Our Ref: BN/7/18/PL

**Town & Country Planning Act 1990 (as amended)
Town and Country Planning (Development Management Procedure) (England) Order 2015
Application for Planning Permission**

Development Erection of 1 No. dwelling & garage (resubmission following BN/61/16/PL). This application is a Departure from the Development Plan.

Location Land to the north of The Flint Barn Yapton Road Barnham

Proposed Plan
 1:100

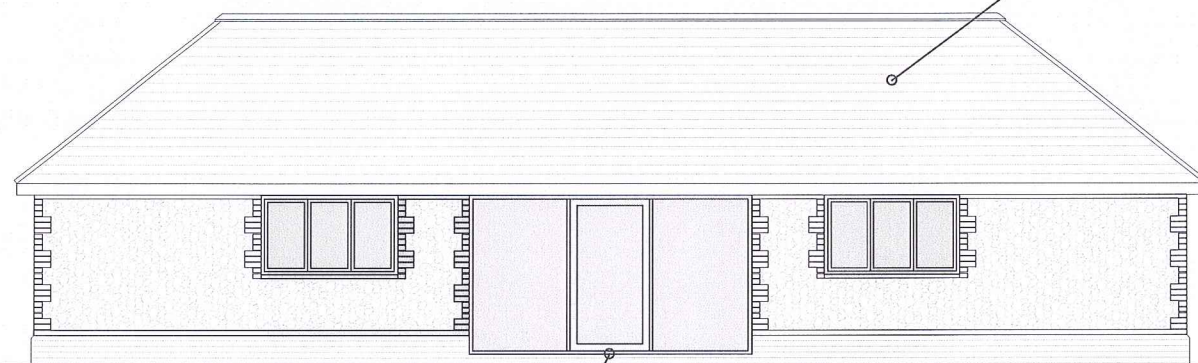
Please show the proposed roof lights on the proposed floor plan.

Drawing  
Proposed gates

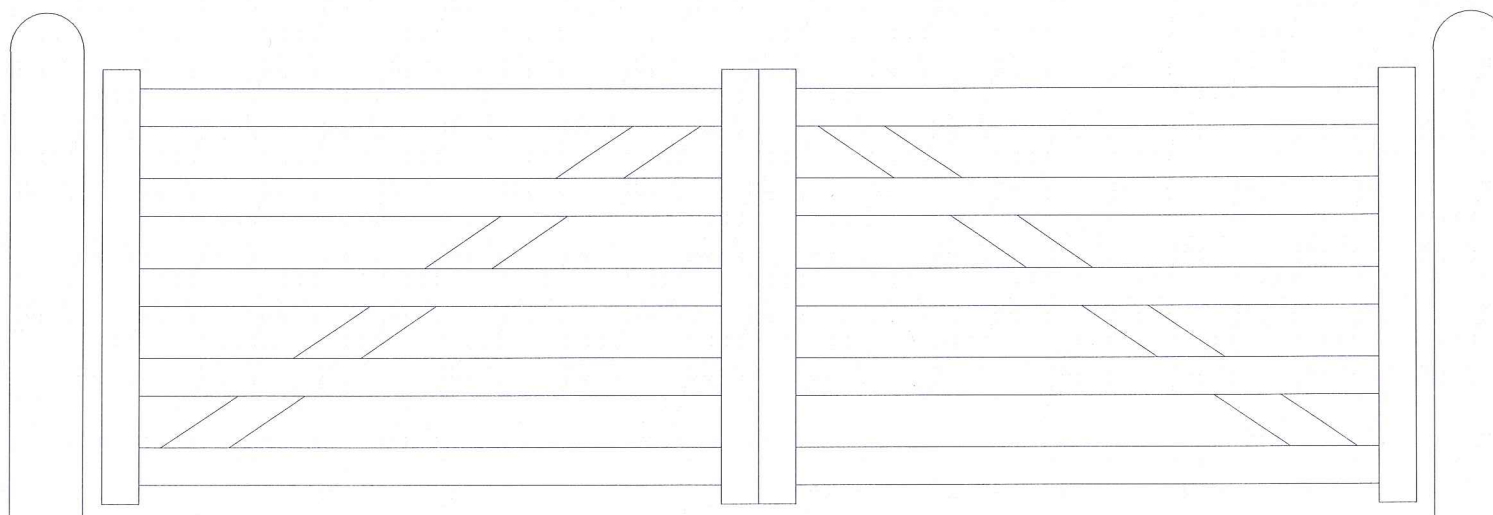
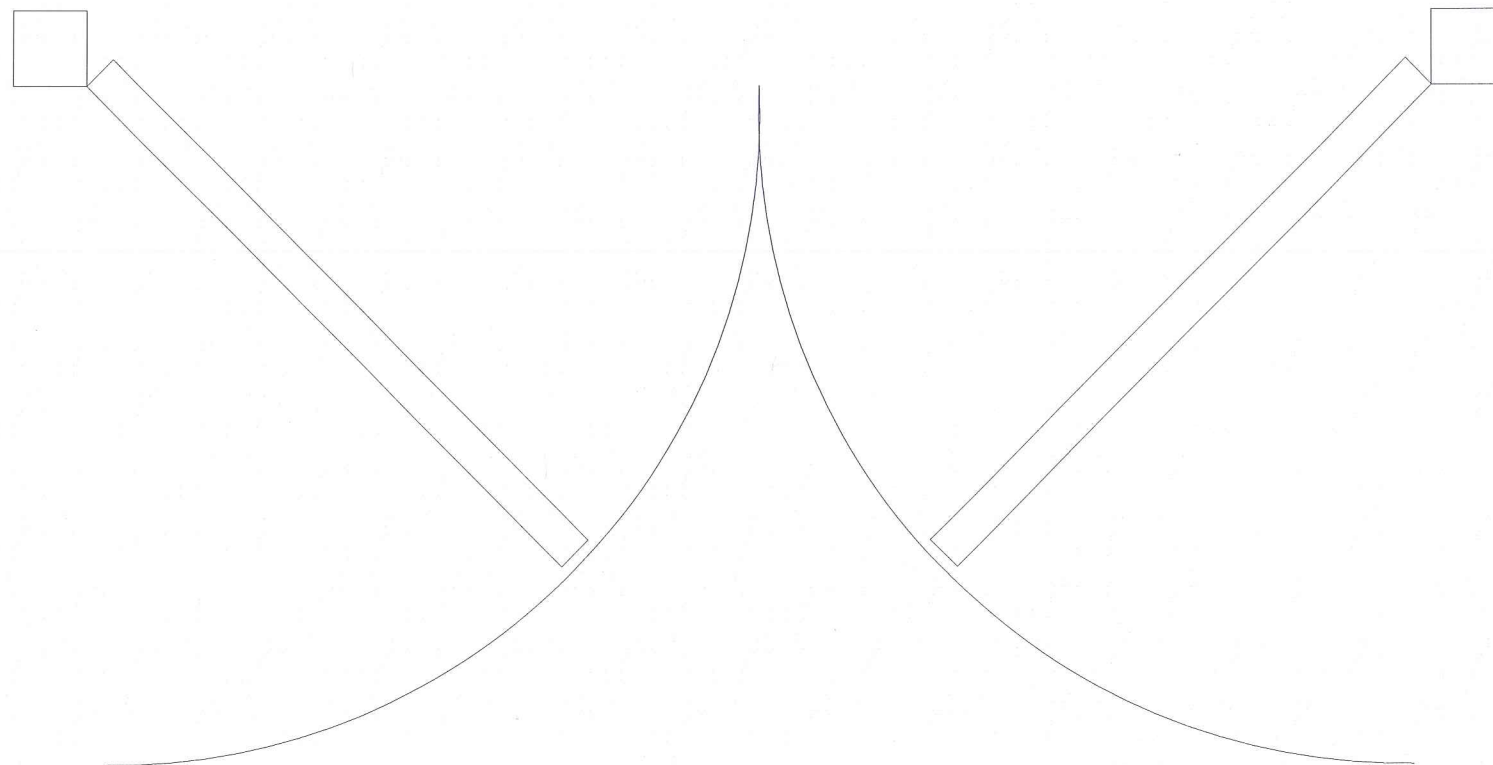
Please provide an elevation of the proposed gates.
